Reference: 20240207-L02_submissions response letter.docx

**RE: 221-291 CROWN STREET, 216-238 KEIRA STREET AND 86-90 BURELLI STREET,
WOLLONGONG – RESPONSE LETTER TO SUBMISSIONS – CIVIL**

Please see below SGC's responses in **GREEN** to the submissions made by the relevant authorities on the civil design associated with the proposed development.

PUBLIC DOMAIN

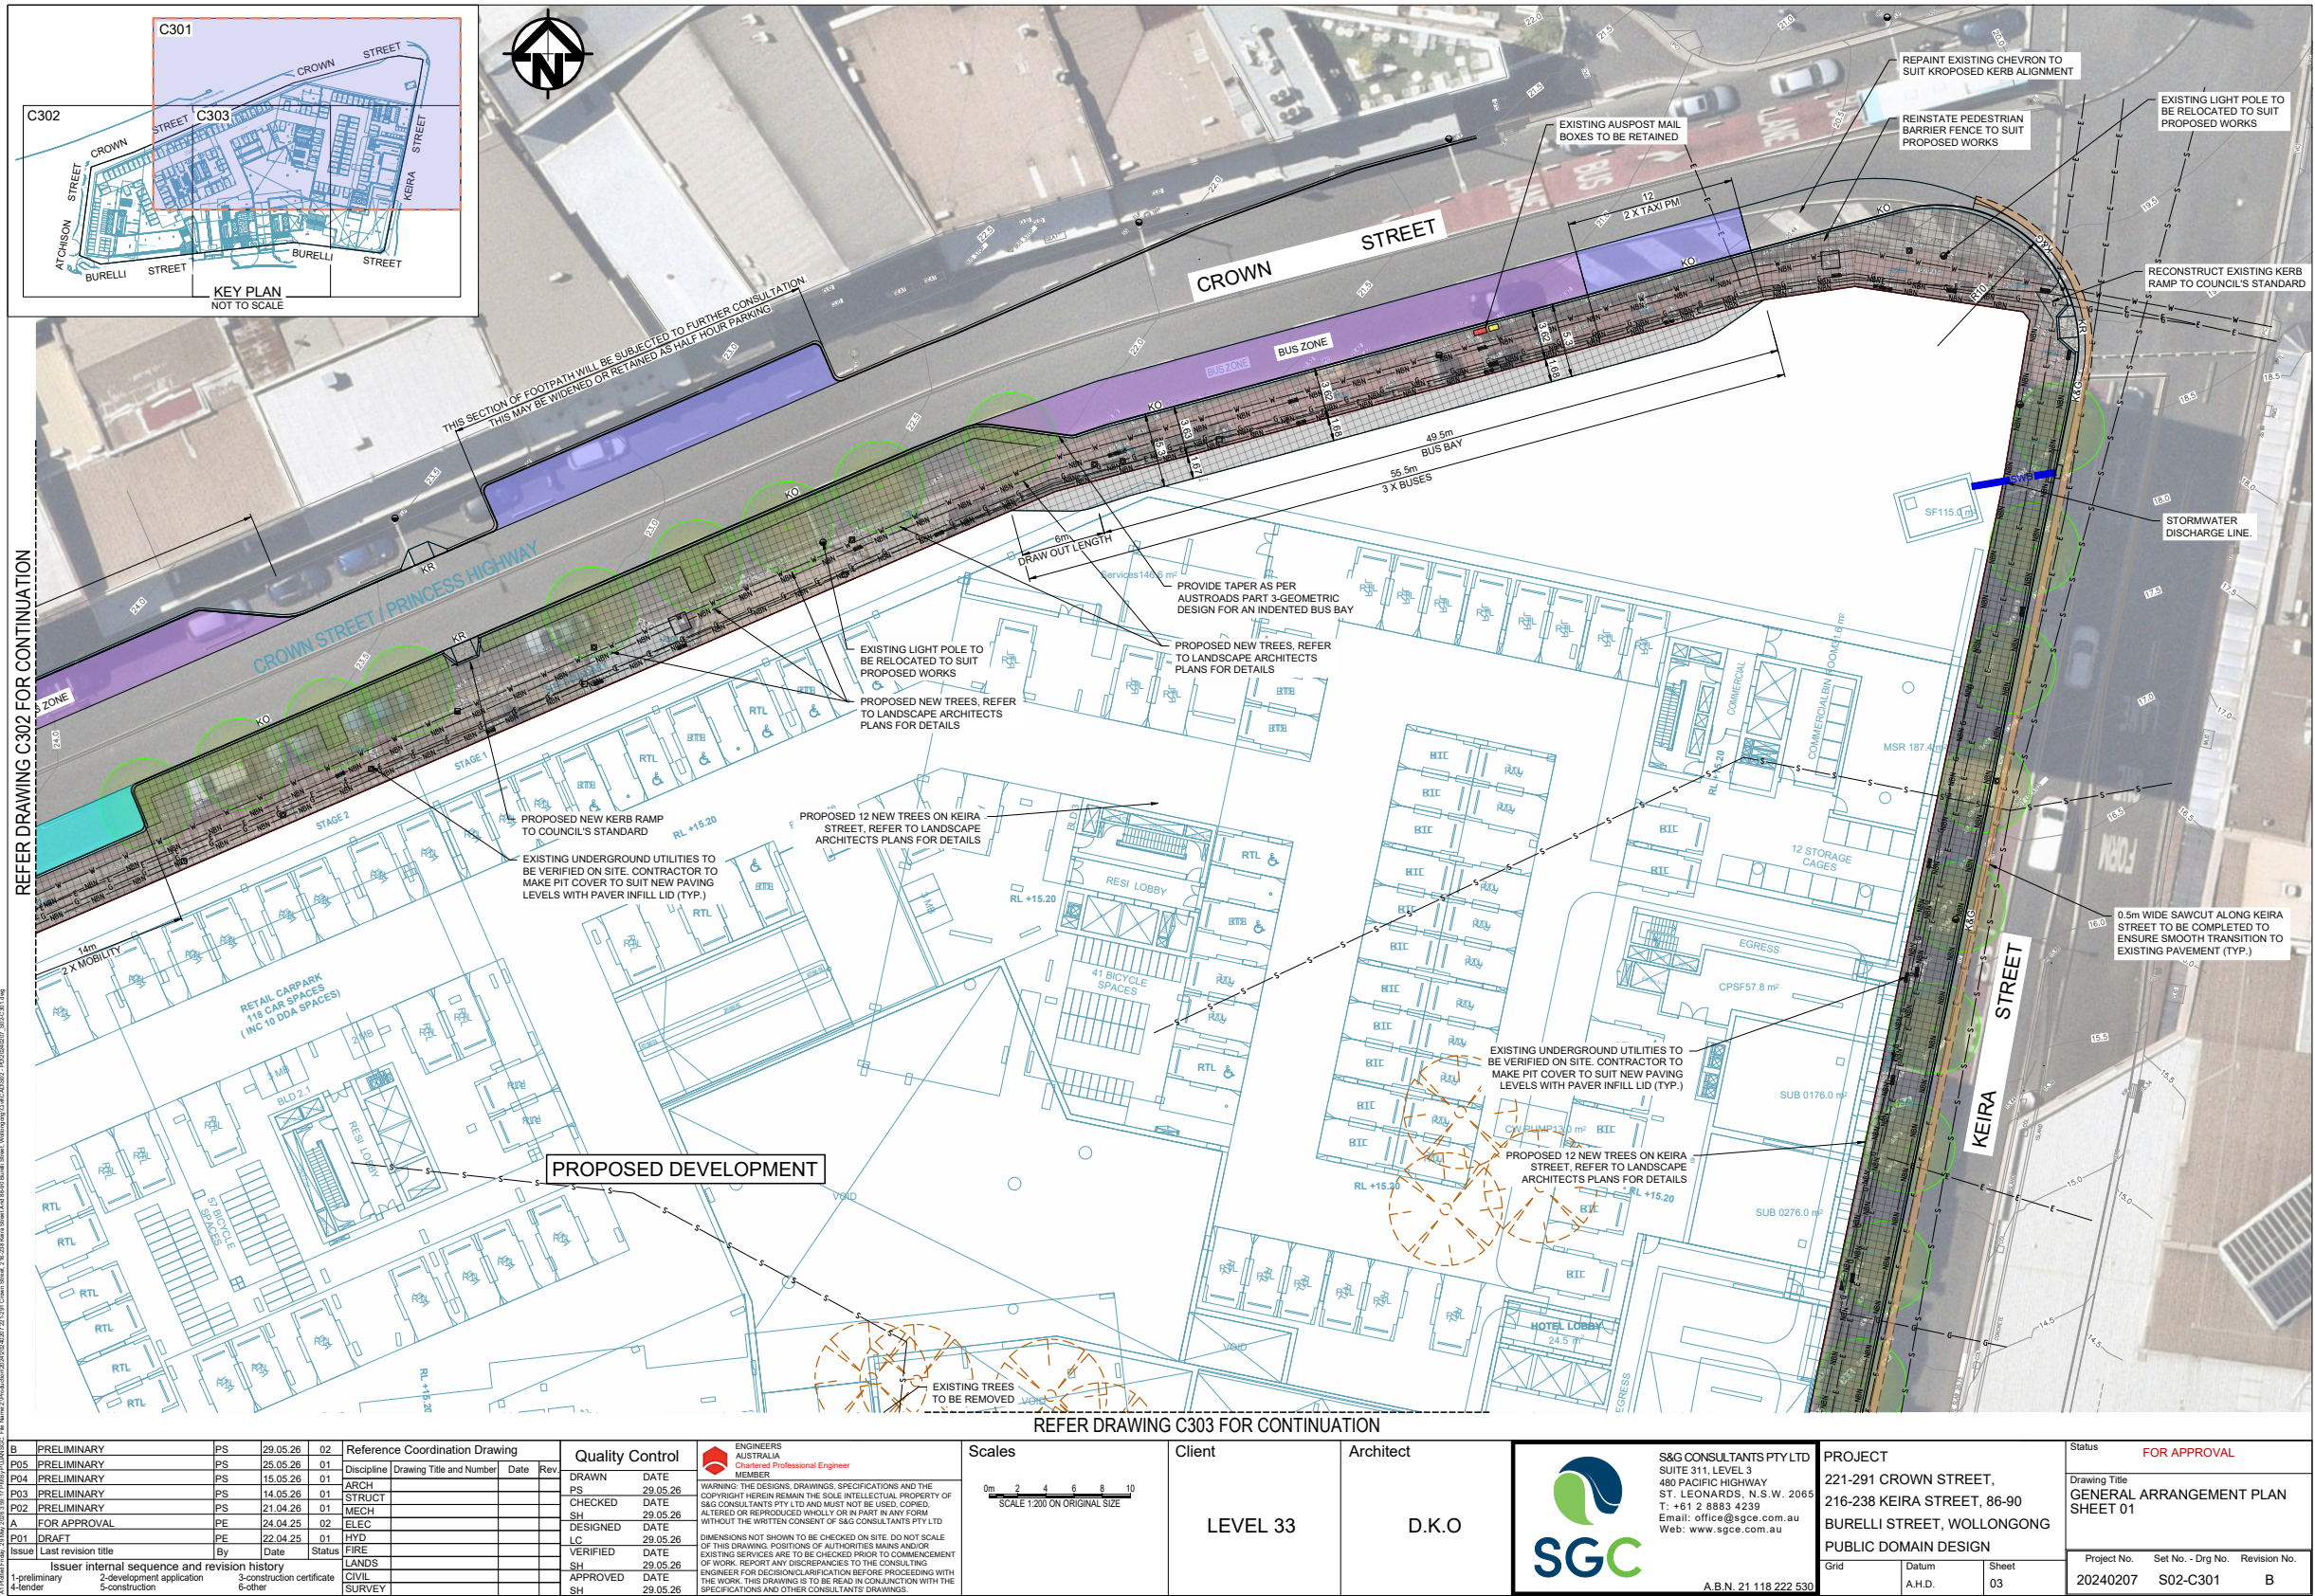
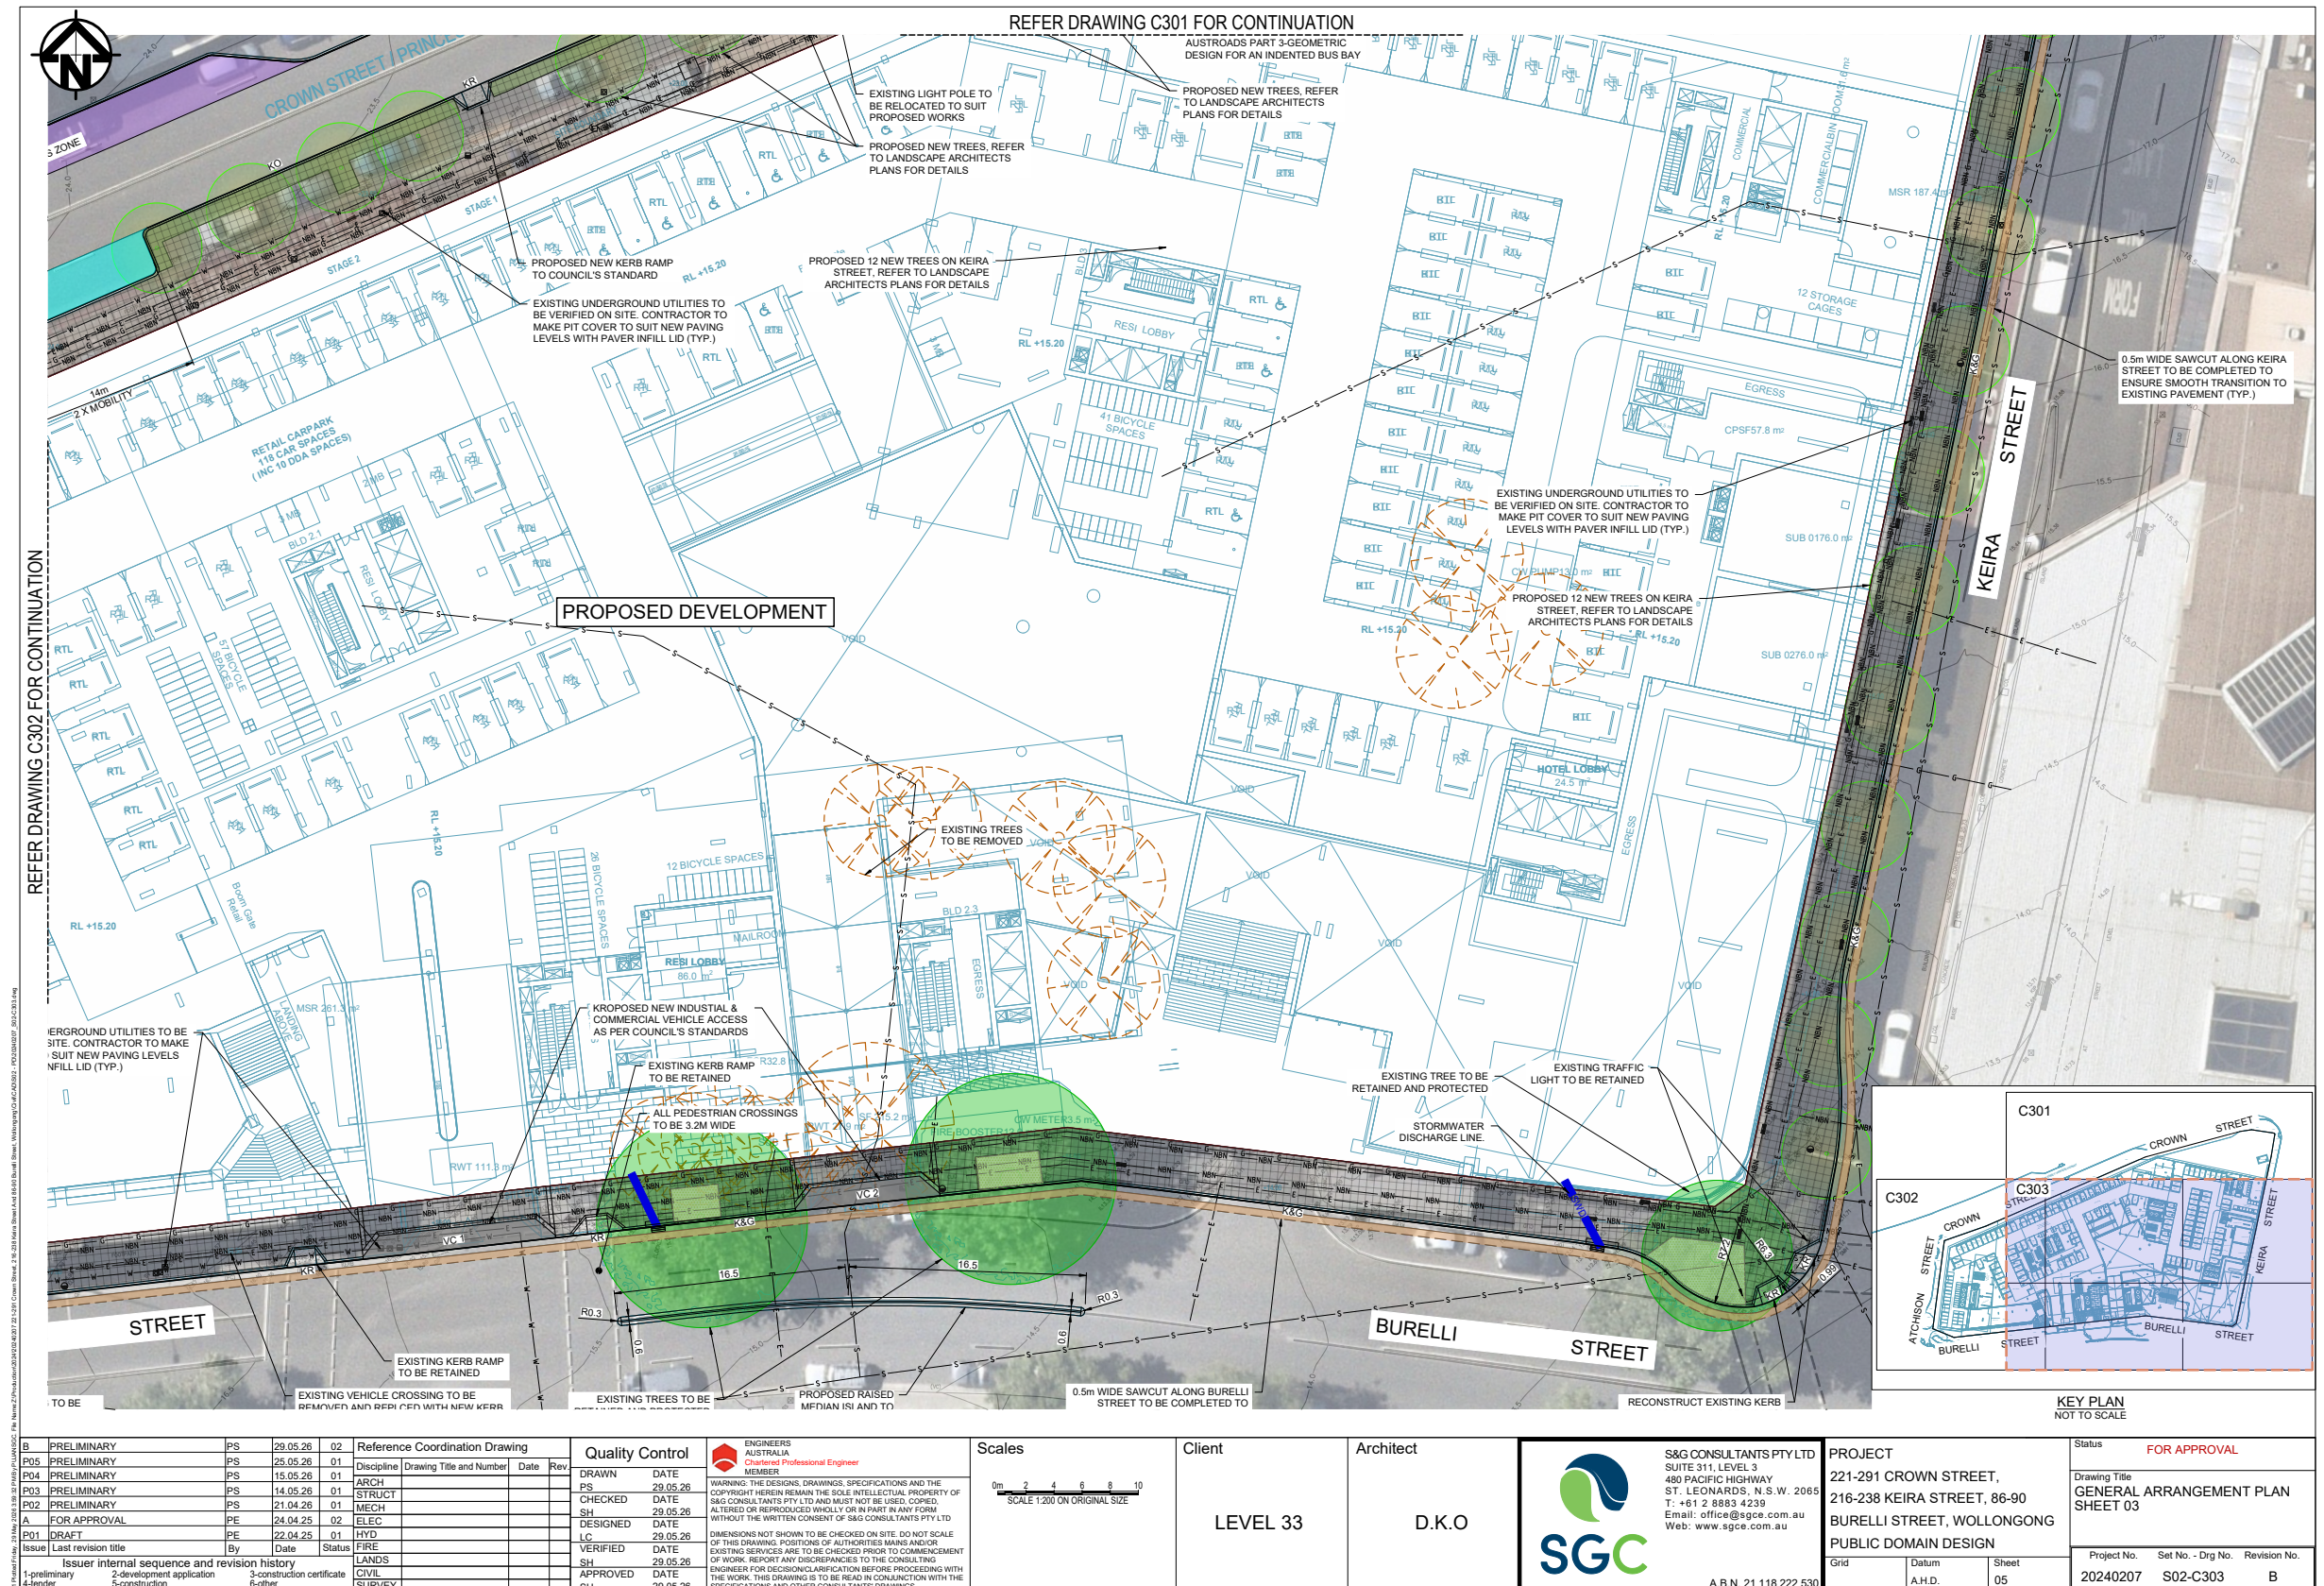
DPHI-9: Provide civil drawings and an updated public domain plan that clearly detail the works required by both Council and TfNSW including:

- the removal of the slip lane on Atchinson Street and signalisation of the intersection
- the redesign of Crown Street to the satisfaction of TfNSW, including the works to accommodate the bus stop relocation and widened kerb alignment on both sides of the street
- the works required on Keira Street including any changes to the kerb alignment
- the works on Burelli Street to accommodate the site access including signalisation of the intersection, removal of crossings and preventing right turns into the site
- swept path diagrams for any relevant vehicles including buses and include details of any regulatory signage and the location of all necessary street infrastructure.

SGC: as per comments in TfNSW Submission Responses. A revised public domain design has been prepared in coordination with traffic and landscaping.
